From:
Sent: 16 February 2026 15:44
To: DC Admin
Subject: Fw: Planning ref 2025/92713

I wish to comment on the recent changes re this planning application:-

PLOT 10

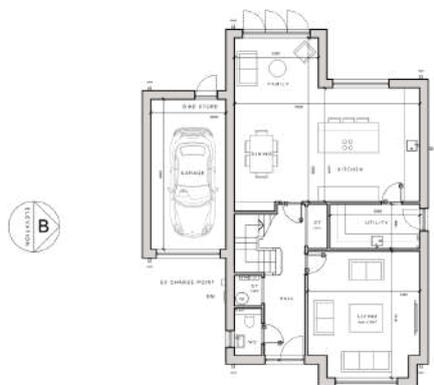
Plots 1 and 10 are the most contentious dwellings. They still show as 5 bed houses (plot 1 is 3 storey) but they should be 2 storey smaller 4 bed houses as per the outline pp granted in 2023.

Plot 10 was 153.5 sq m in 2023 and now 185.8 sq m.

PLOT 1

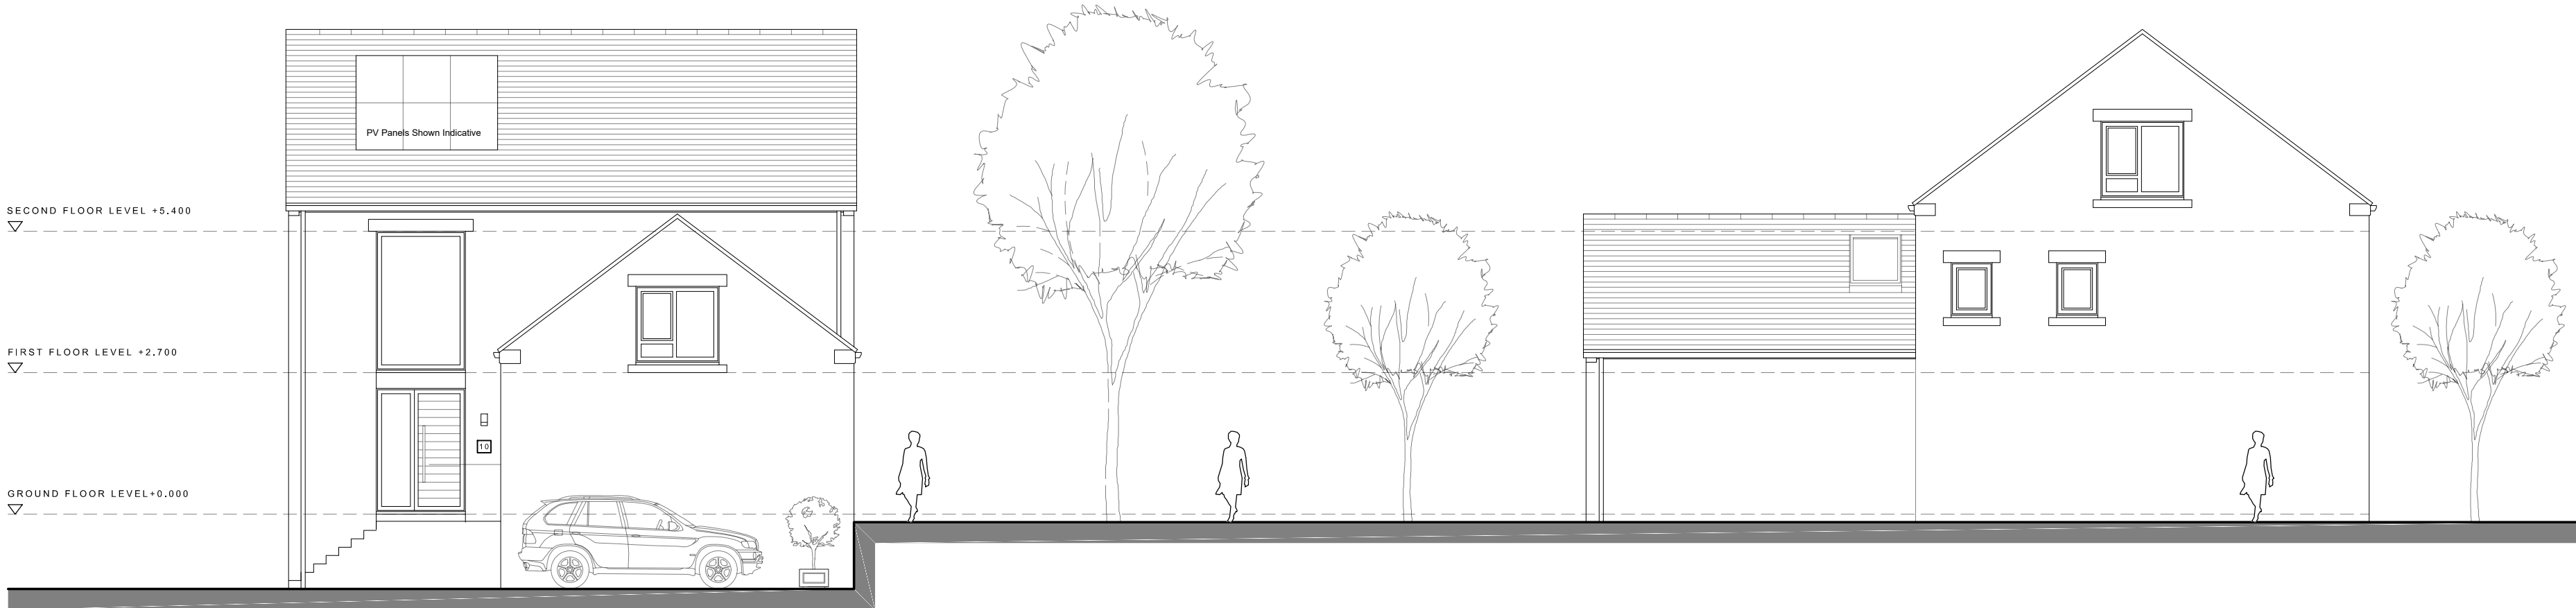
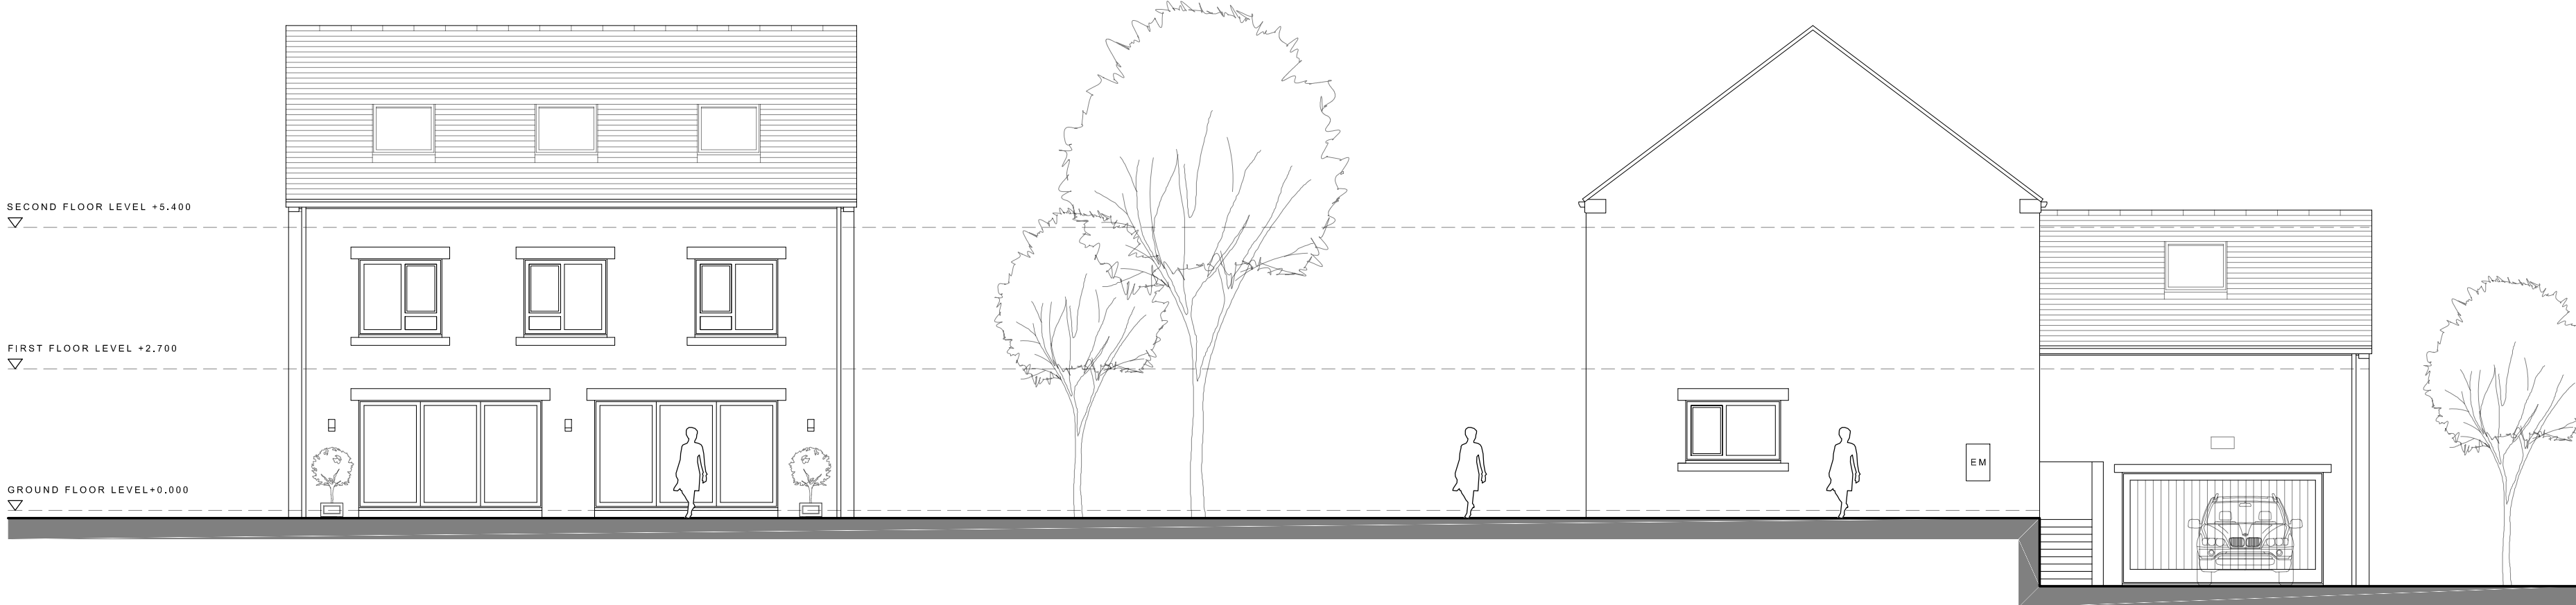
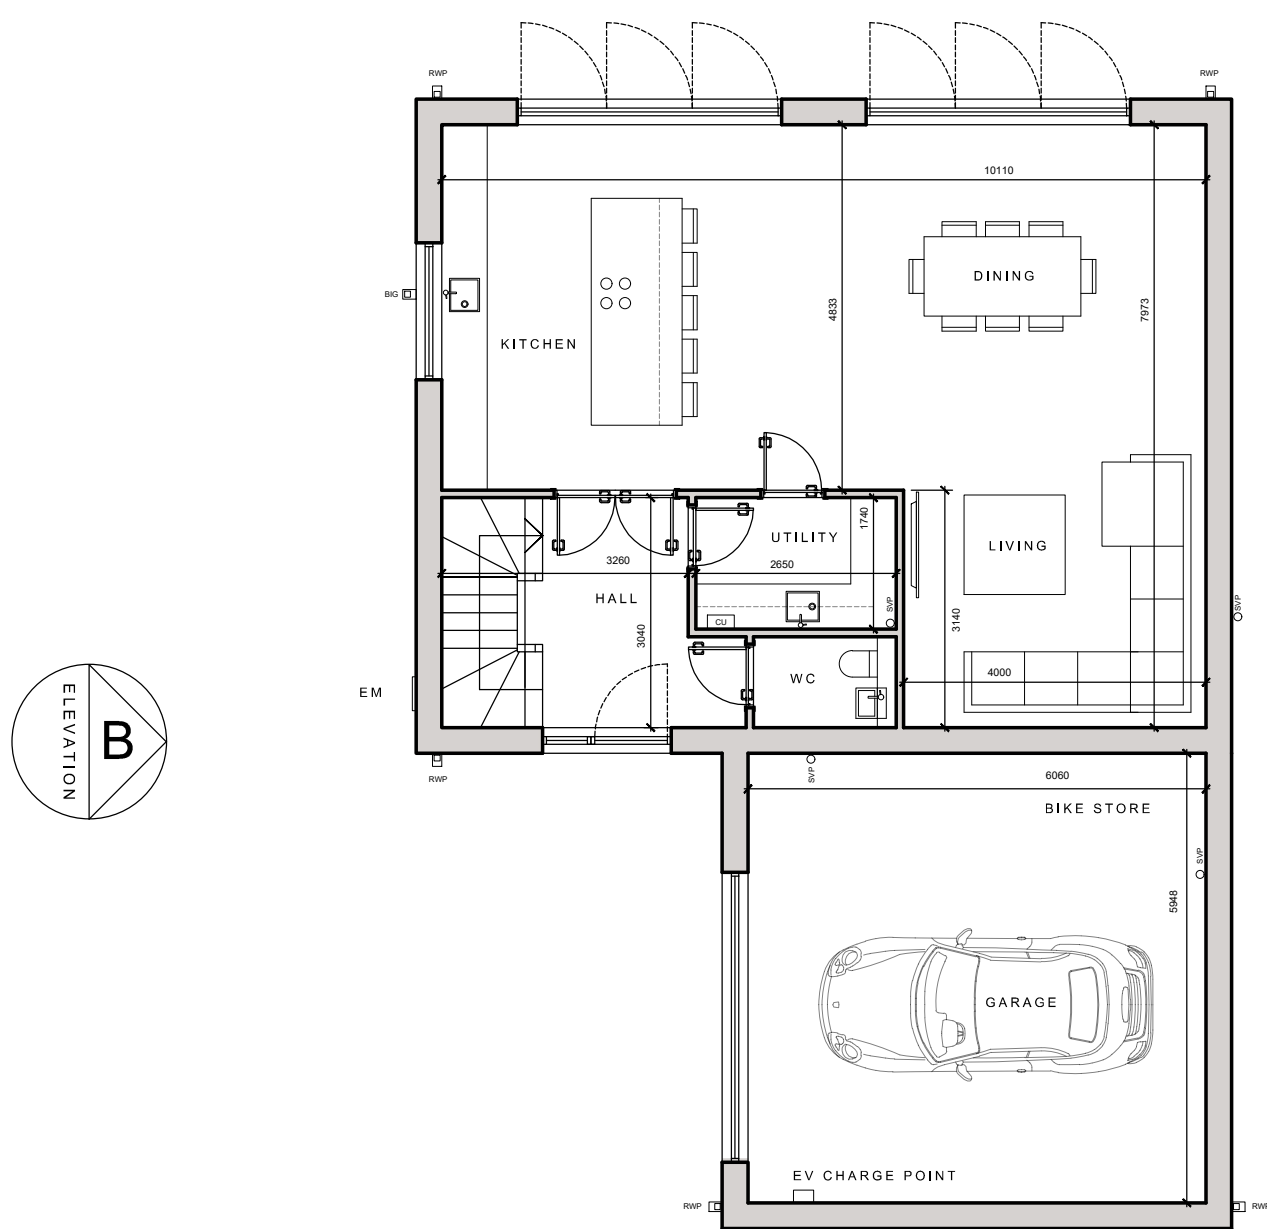
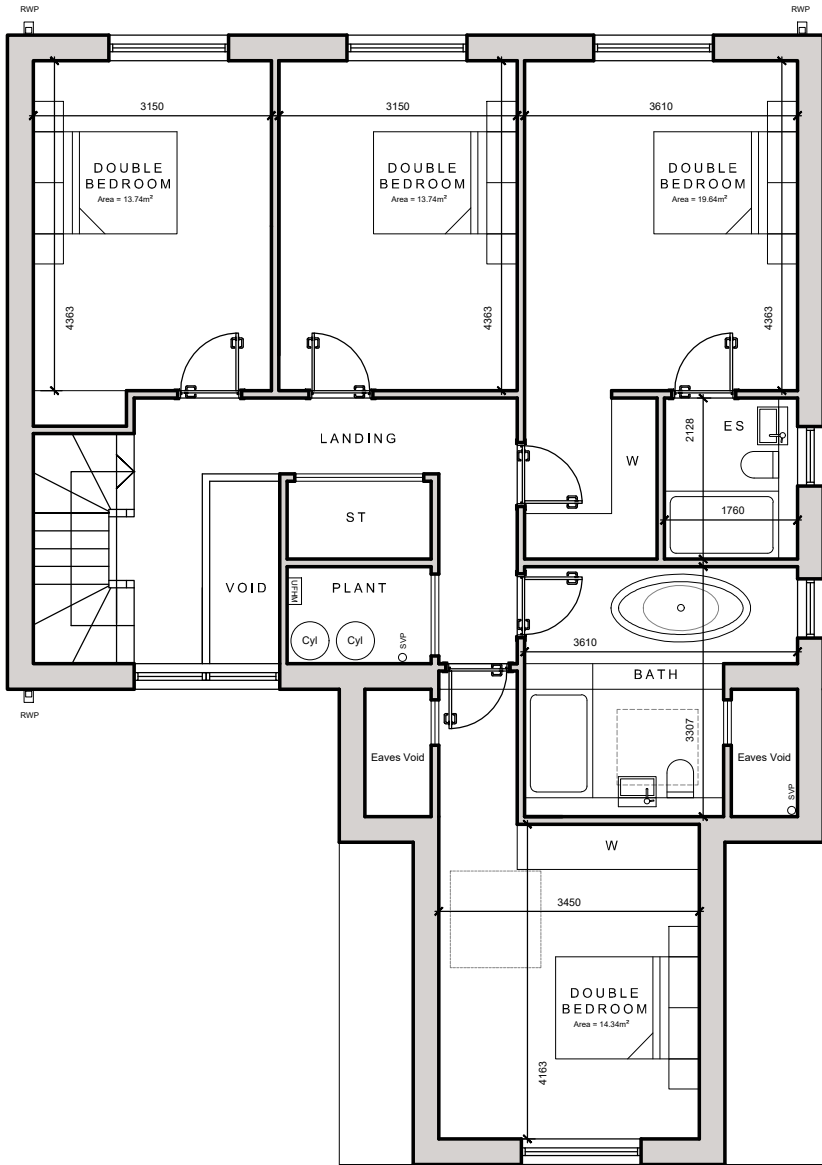
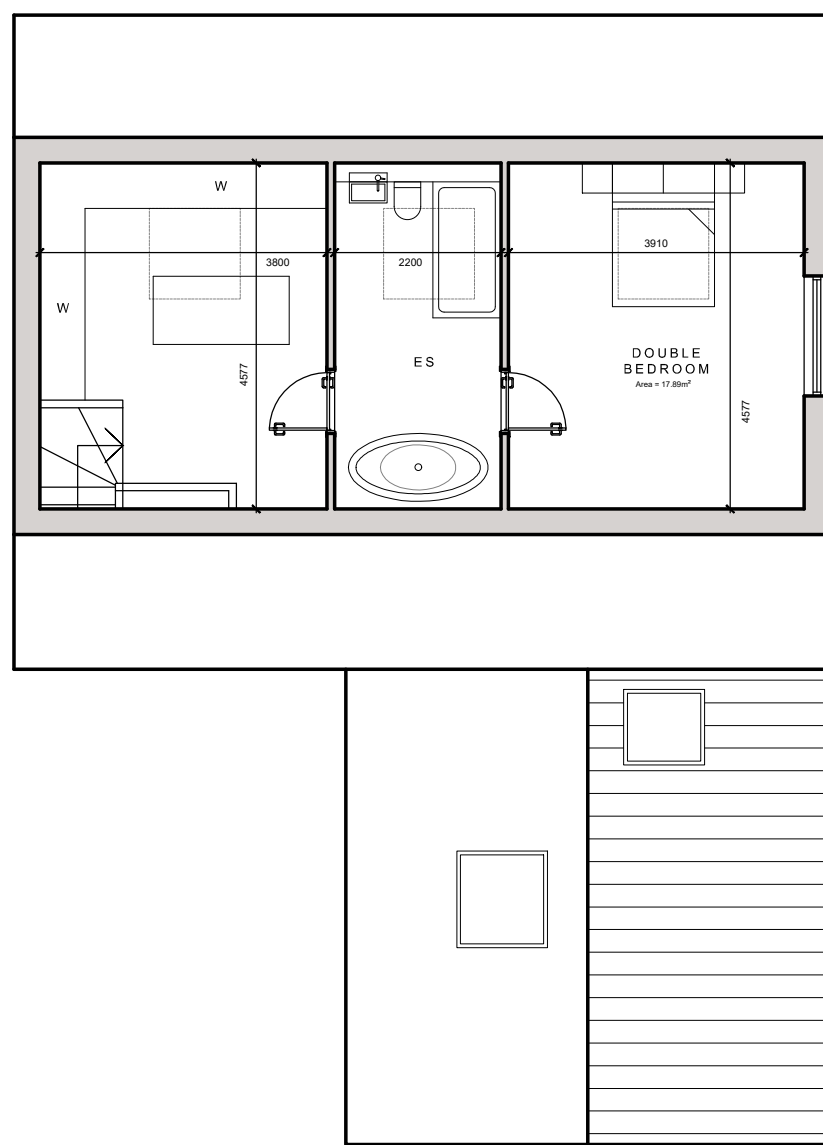
Plot 1 originally had a house area of 161.4 sq m on outline pp in 2023 but this has increased to 225.21 sq m excluding garage in 2025.

PLOT 2

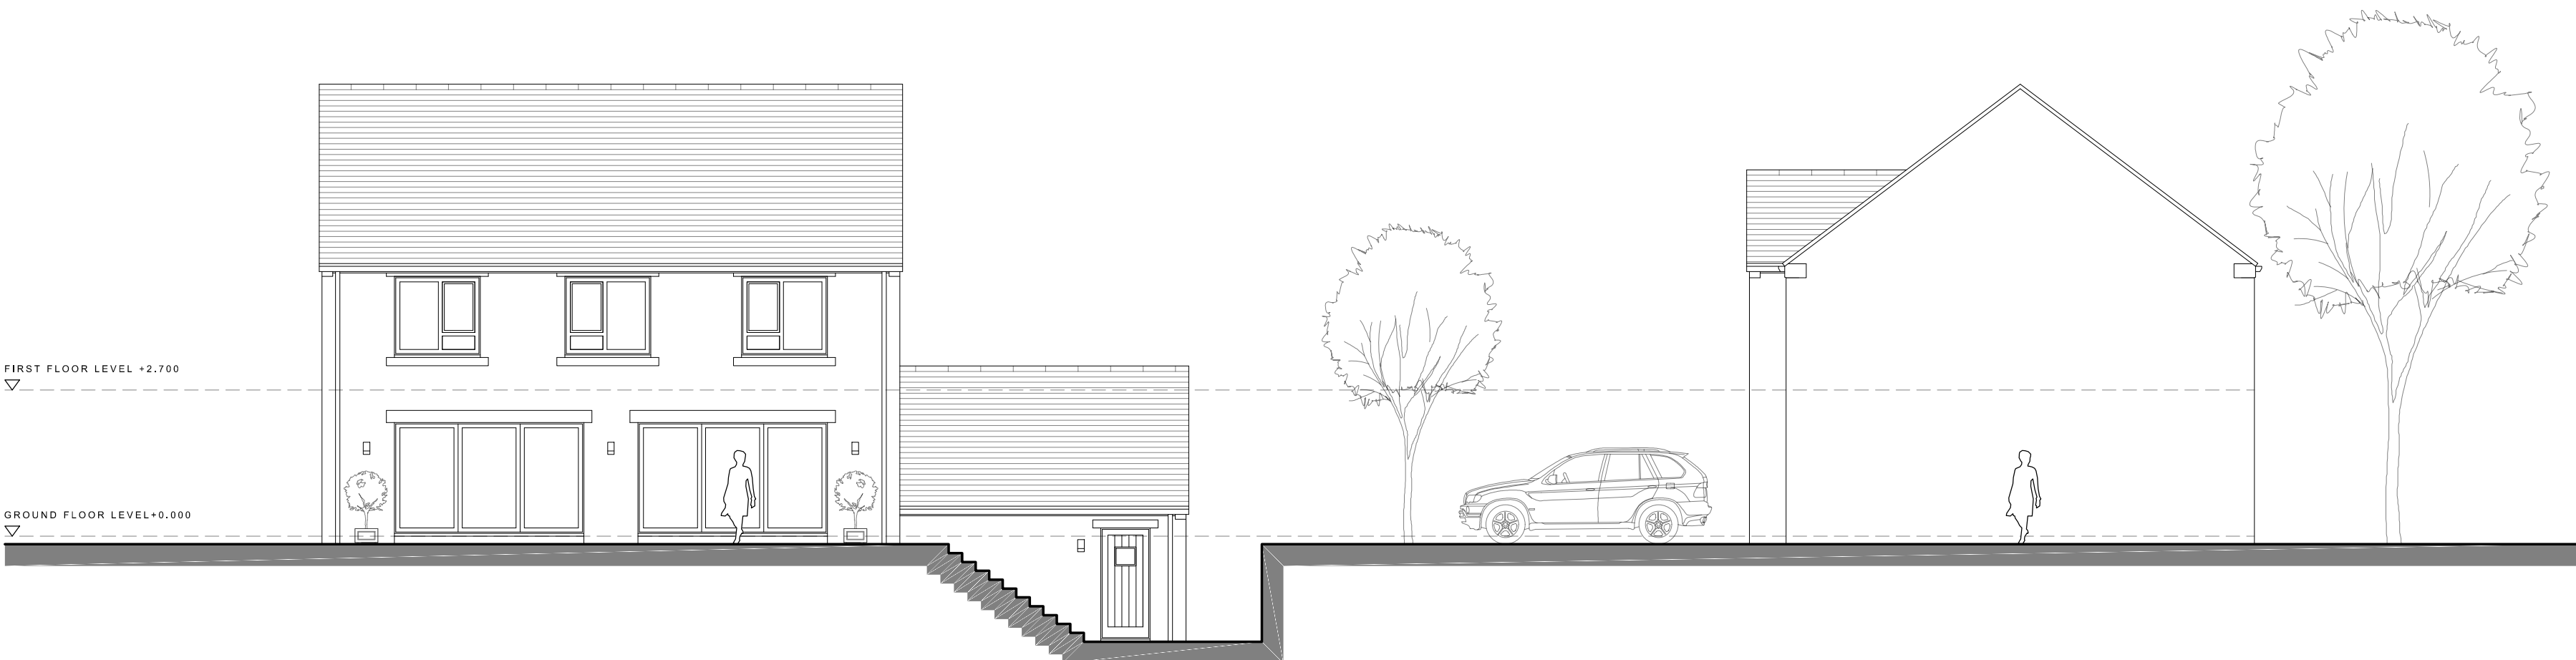
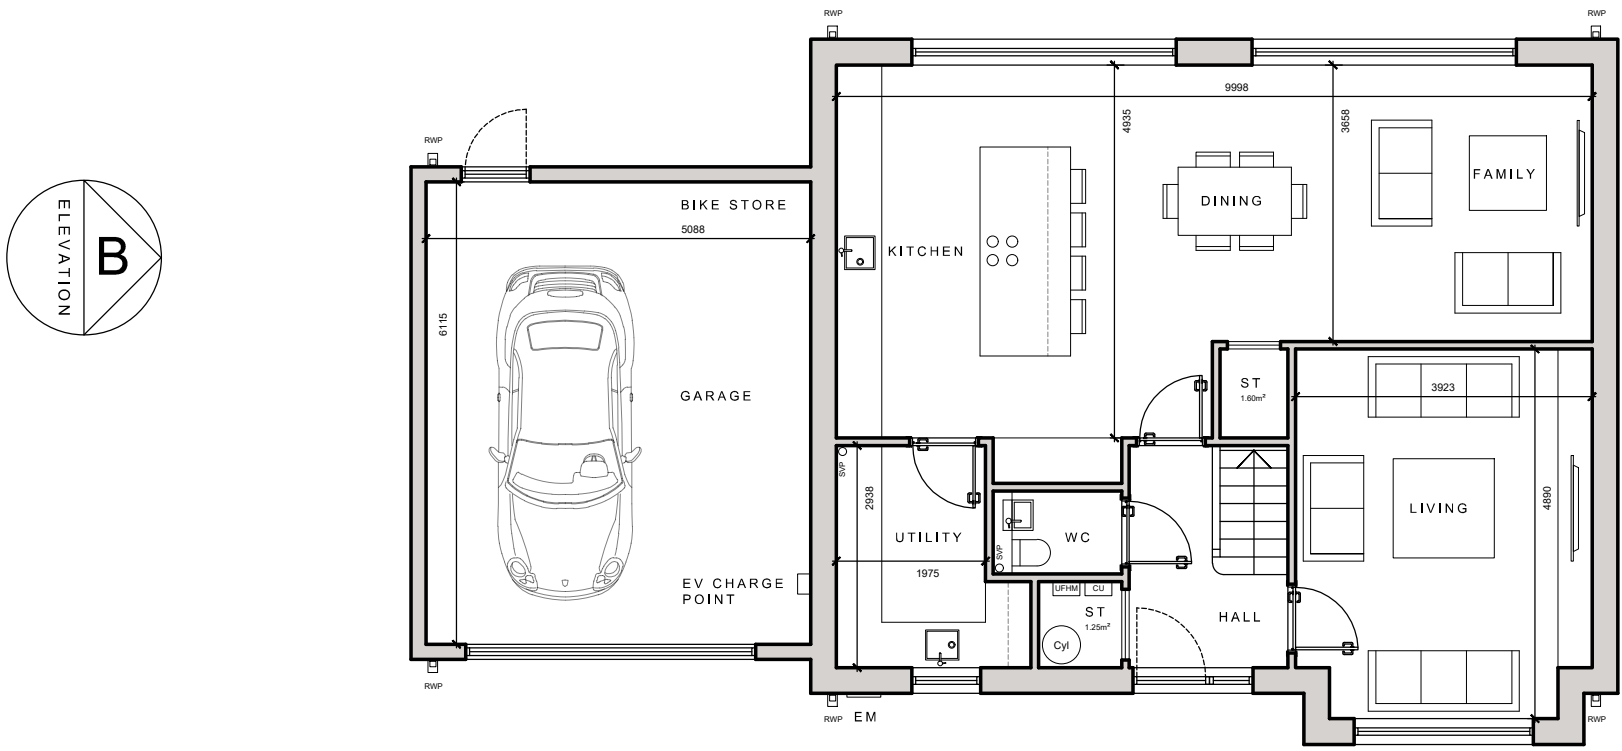
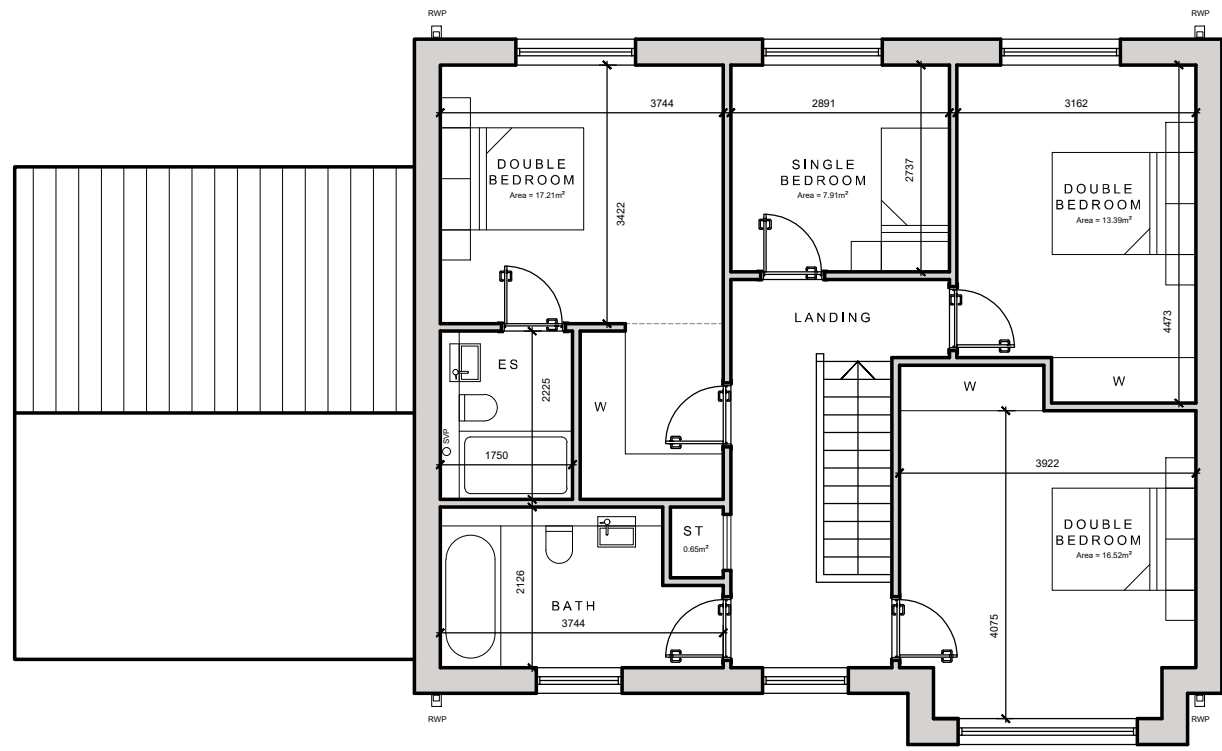
Plot 2 was 161.4 sq m in 2023 and now 163.48 sq m excluding garage in 2025.
